**Re: 2025/92385- Change of use from dwelling (C3) to children's home for up to 4 children at 66 Carlinghow Hill, Upper Batley, Batley, WF17 0AG**

Agnieszka Boryn  
Designing Out Crime Officer  
Kirklees District

66 South Field - Site Plan

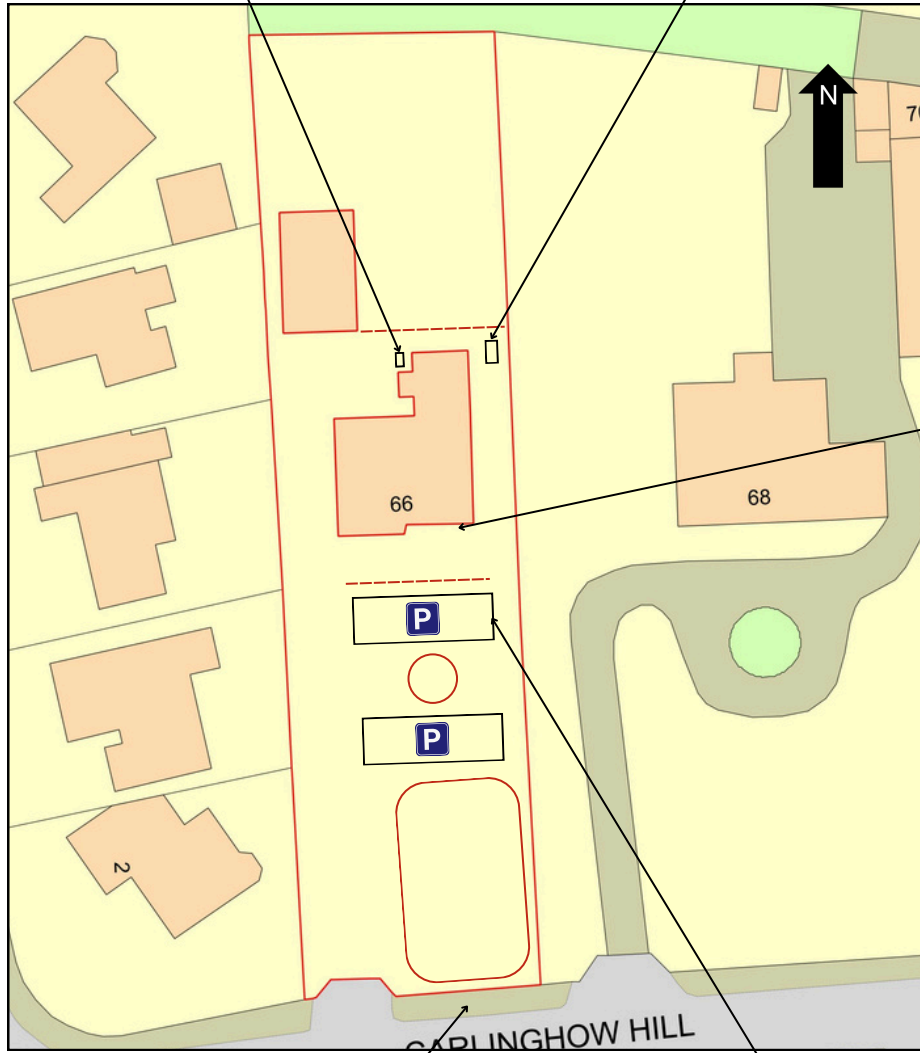
Cycle stands should be rated to Sold Secure Silver due to being located outside. Bin enclosure should be lidded and locked when not in use to prevent the bins from being utilised as climbing aids.
